The Secretary
NSW Department of Planning, Industry and Environment

1 May 2021

I refer to the Department's attached email of 28 April 2021 regarding State Significant Development SSD-9522 Kemps Creek Warehouse, Logistics and Industrial Facilities Hub MOD 1 - Changes to Lot 5 for 'Modification of the site layout to accommodate changes to Lots 5-8' at 657-769 Mamre Road, Kemps Creek (Lot 34 DP 1118173, Lots X & Y DP 421633, Lot 1 DP 1018318, Lot 22 DP 258414). Submissions need to be made to the Department by 13 May 2021.

Figure 1: Site Plan

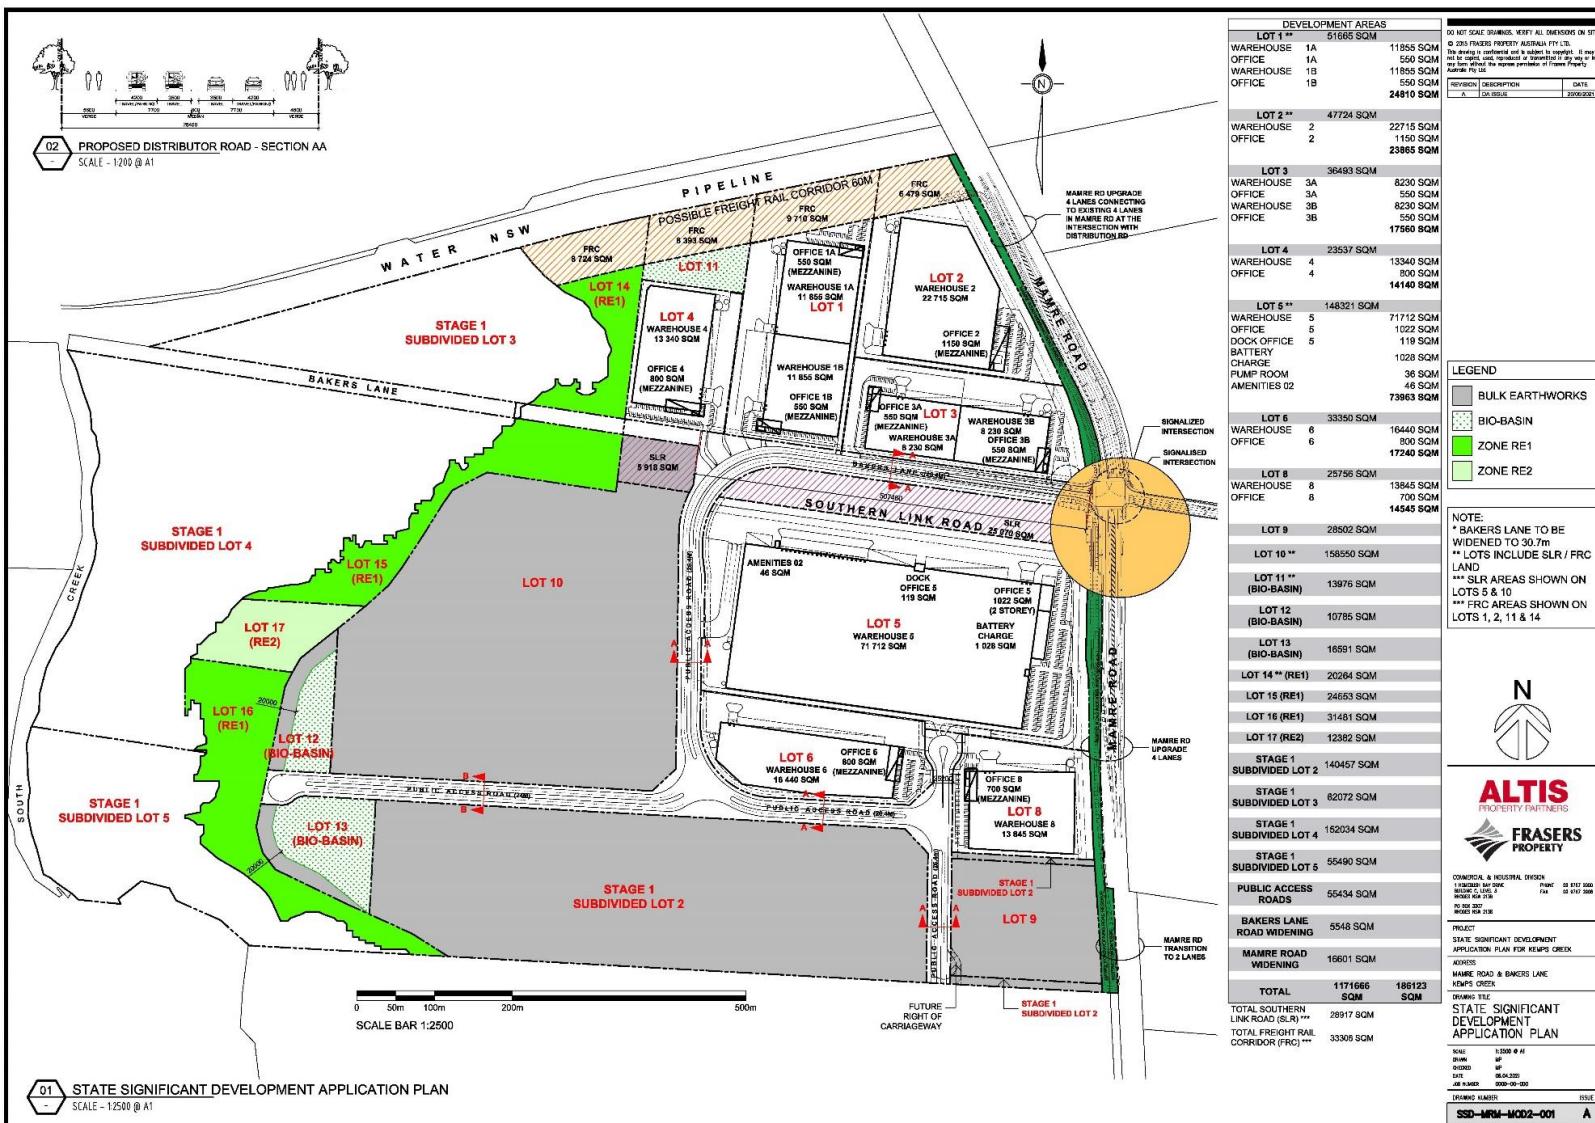
Endeavour Energy has noted that as shown in the following extract of Site Plan (Warehouse 6 & 8) provision has been made for two padmount substations.

From Endeavour Energy's perspective the fact that provision is being made for a padmount substation is a positive. Endeavour Energy's general requirements is for a padmount substation to be at ground level and have direct access from a public street (unless provided with appropriate easements for the associated underground cables and right of access).

- Easement with a minimum size of 2.75 x 5.5 metres (single transformer).
- Restriction for fire rating which usually extends 3 metres horizontally from the base of the substation footing / plinth and 6 metres vertically from the same point.
- Restriction for swimming pools which extends 5 metres from the easement (which is usually not required for non-residential development).

The easement should not cross property boundaries but the restriction/s may affect any adjoining property provided they are able to be registered on the title to that property. In addition the following matters also need to be considered in regard to the fire restriction:

- Personnel access doors and fire exit doors to a building are not permitted within the fire restriction area.
- Gas mains/pipes shall not pass through the fire restriction area.

- A 10 metre clearance distance shall be maintained between substation and fire hydrants, booster valves, and the like in accordance with AS2419.1 'Fire hydrant installations System design, installation and commissioning' as updated from time to time.
- Consideration should be provided to the appropriateness of the landscaping relative to the fire restriction for the substation. Any landscaping that potentially could transfer / provide connectivity for flame or radiant heat from a fire in the substation to a dwelling or building should be avoided.
- The storage of and / or use of flammable, combustible, corrosive or explosive material within the fire restriction should be avoided.

Generally it is the Level 3 ASP's responsibility (engaged by the developer) to make sure that the substation location and design complies with Endeavour Energy's standards the suitability of access, safety clearances, fire ratings, flooding etc. As a condition of the Development Application consent Council should request the submission of documentary evidence from Endeavour Energy confirming that satisfactory arrangements have been made for the connection of electricity and the design requirements for the substation, prior to the release of the Construction Certificate / commencement of works.
